# DRB CASE ACTION LOG

DRB Application No.: 10DRB-70322 Project # 1008565  
 Project Name: MESA VERDE  
 Agent: THE SURVEY OFFICE Phone No.:

**DRB Comments**

**RE: Lots 22-24, Block 16, Mesa Verde Addition**

PLAT OF
 LOTS 23-A & 24-A, BLOCK 16
 MESA VERDE ADDITION
 SECTION 19, T. 10 N., R. 4 E., N.M.P.M.
 CITY OF ALBUQUERQUE
 BERNALILLO COUNTY, NEW MEXICO
 NOVEMBER 2010
 SHEET 2 OF 2

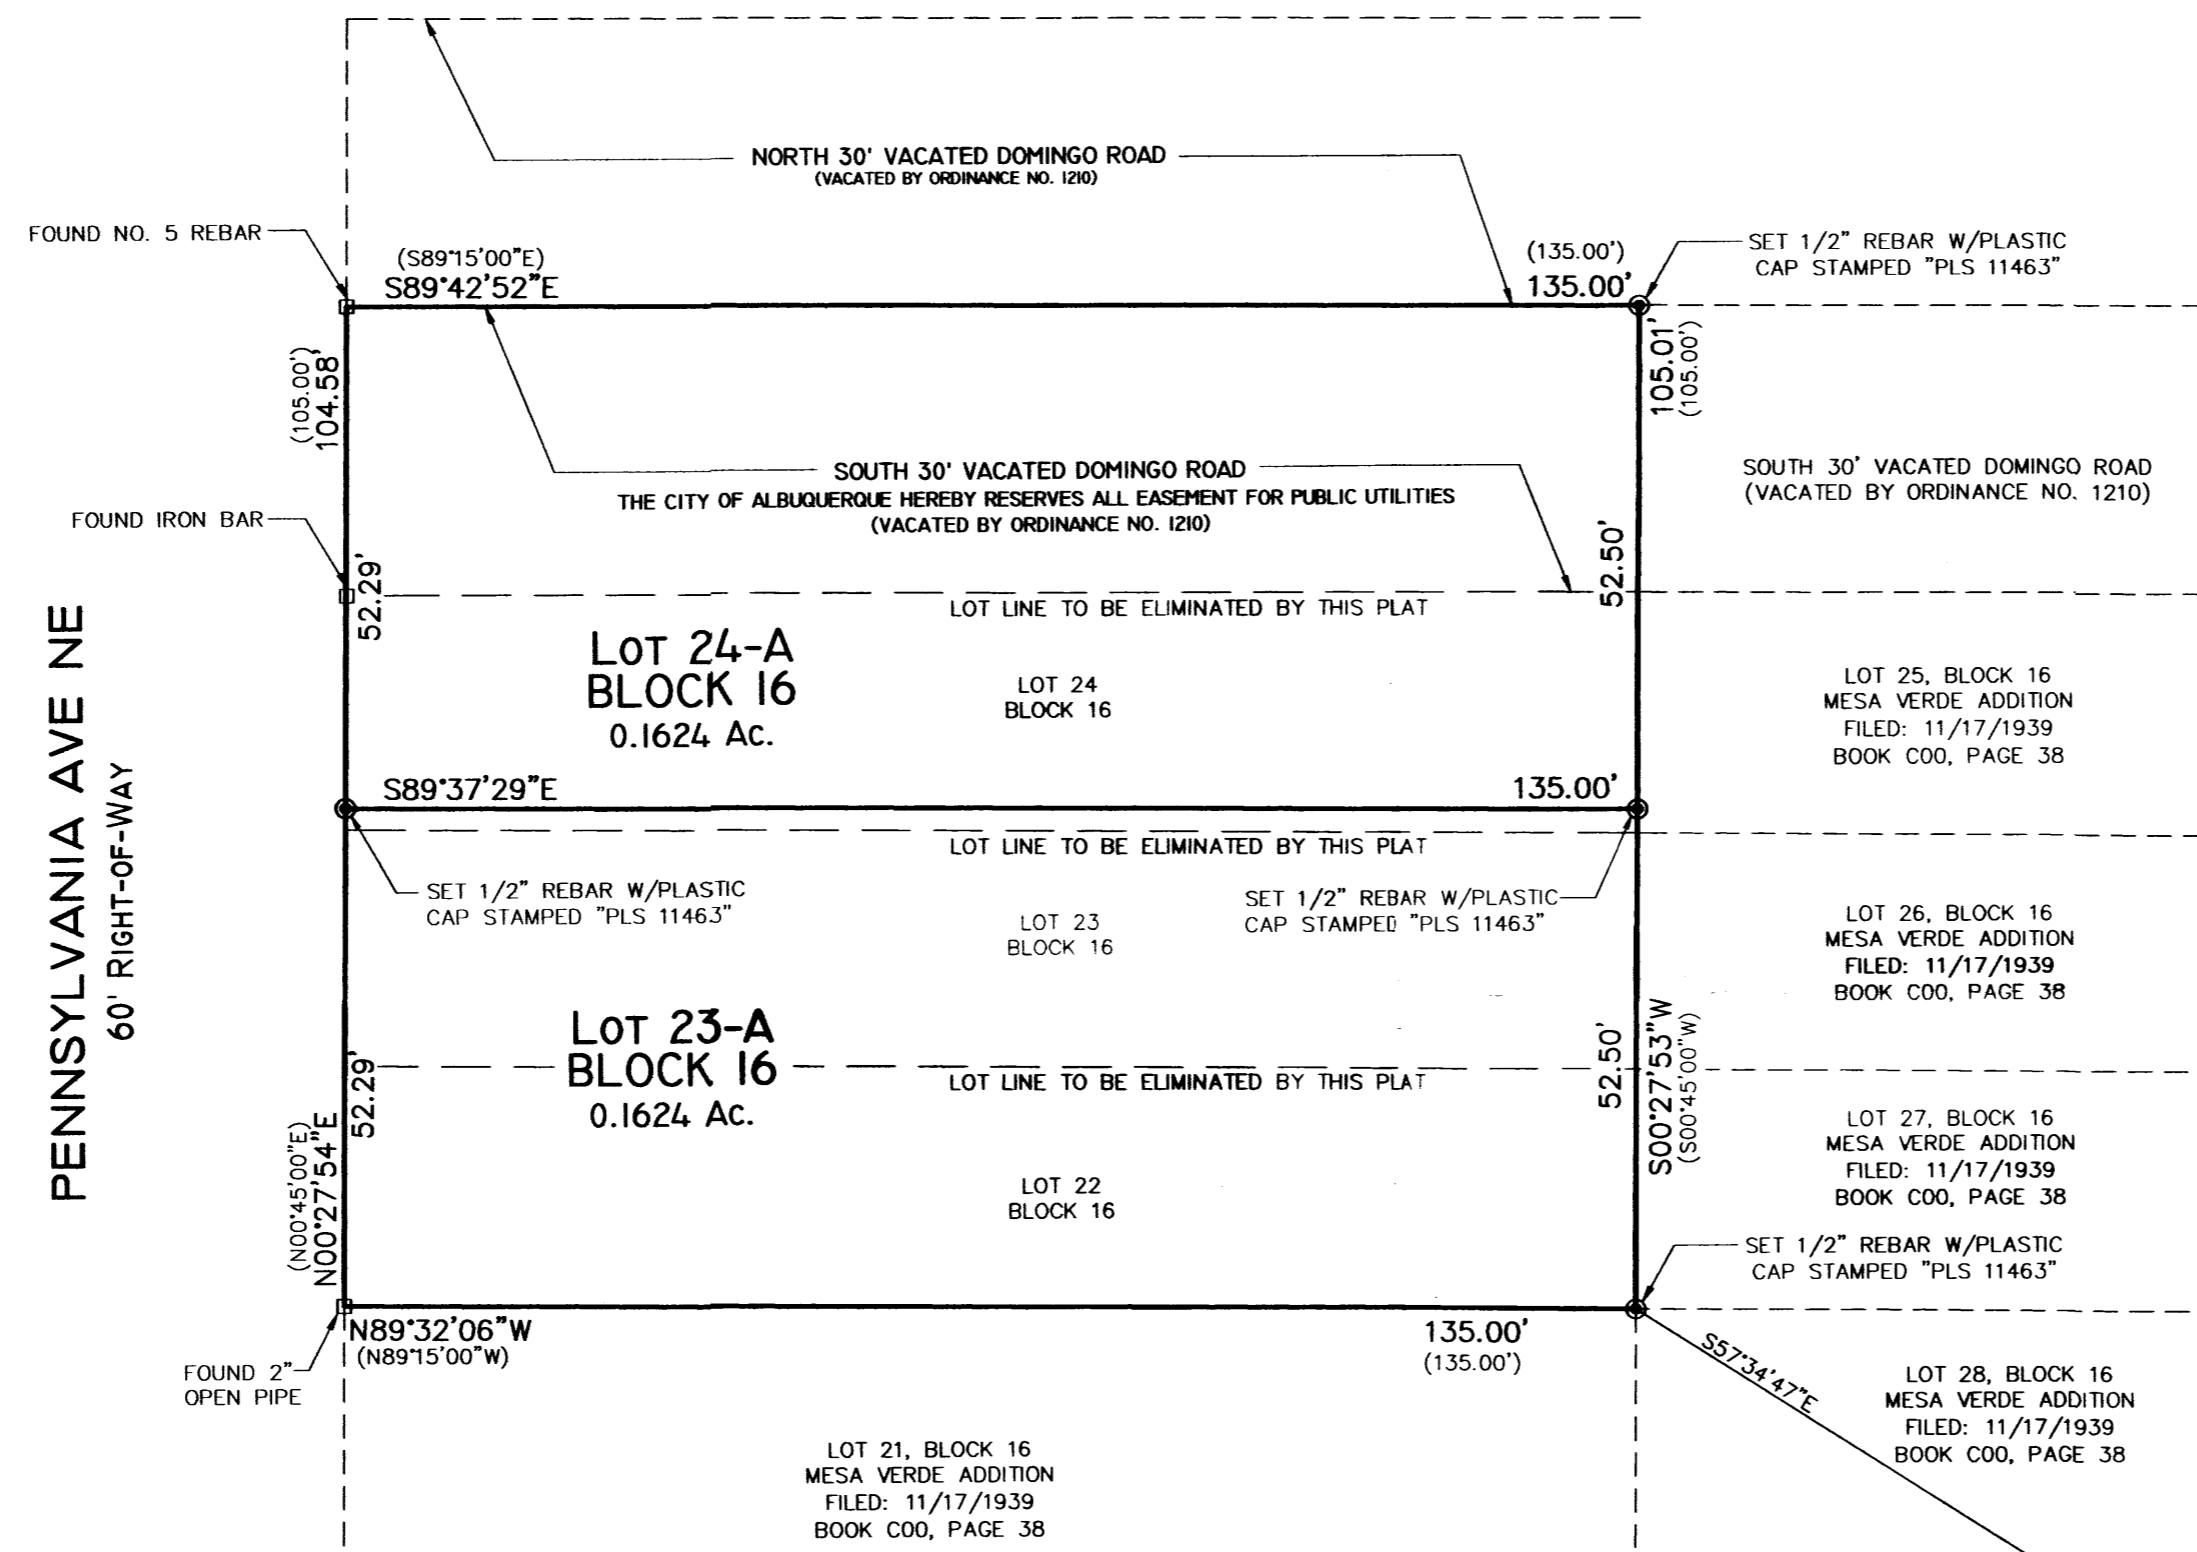
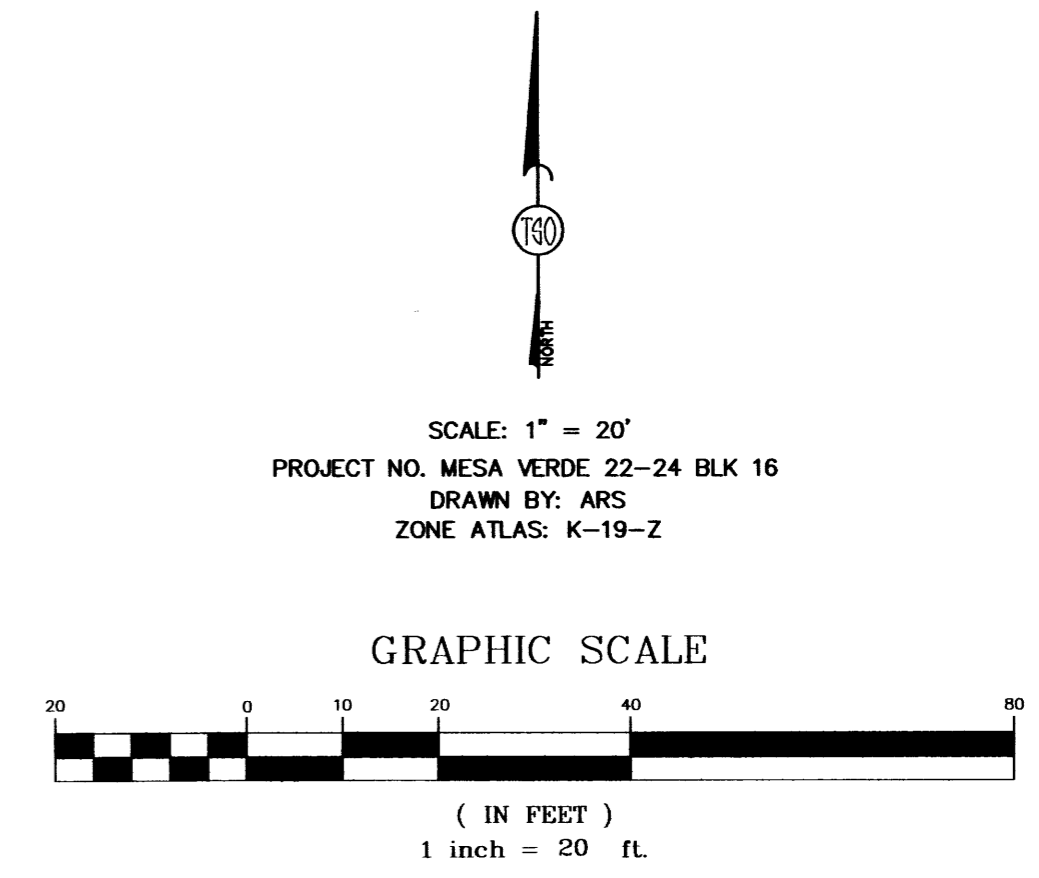
PLANNING (Last to sign): - verify fence relocation  
- drop file

Vacation Ordinance No. 1210 retained public easements (page 2, Section II) – this needs to be called out on plat, but they may be eligible for vacation through a public hearing and the plat process.
